Consultee Comments for Planning Application 21/02033/FUL

Application Number: 21/02033/FUL

Address: Weeping Ash Ardleigh Road Great Bromley Colchester Essex CO7 7TL

On Behalf Of: Tree & Landscape Officer

Block Plan Plot 1 Scale 1:200

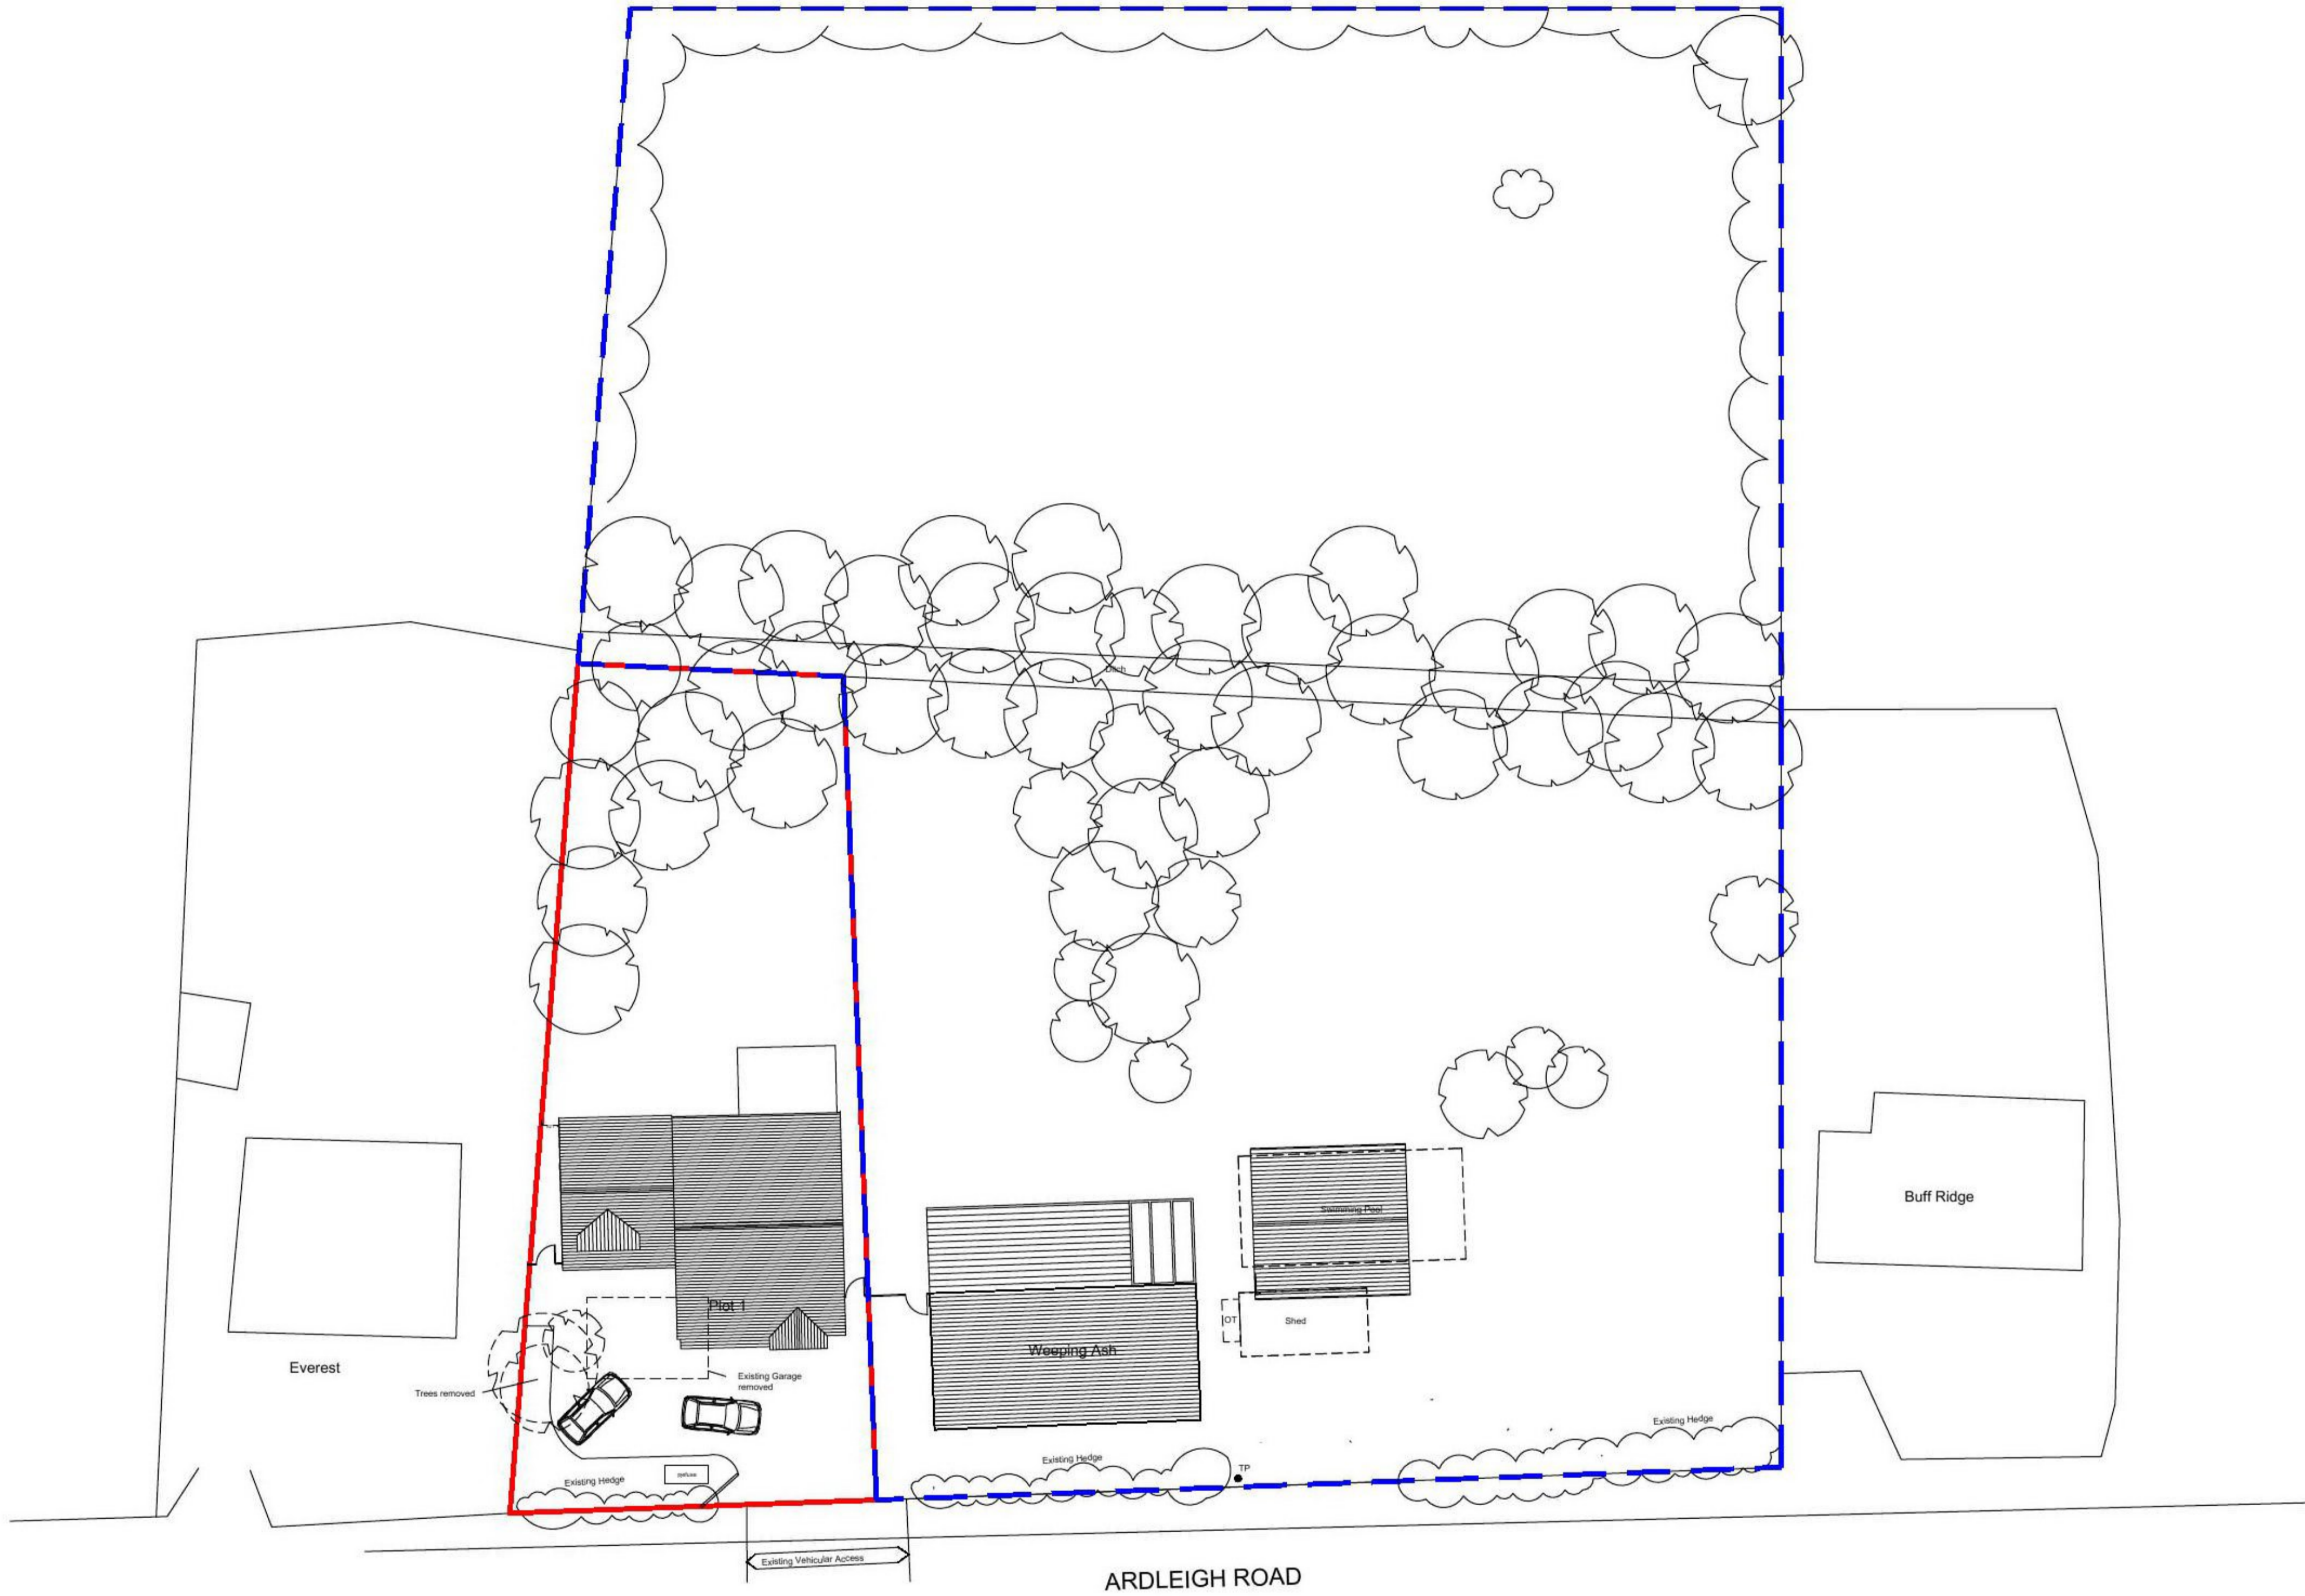
From an examination of the proposed site layout it appears that it may be possible to retain the Tortured Willow; if this is not possible then the amenity value of the existing tree could be relatively easily replicated by the planting of a replacement tree.

Should planning permission be likely to be granted then details of soft landscaping for the front garden should be secured by a planning condition.
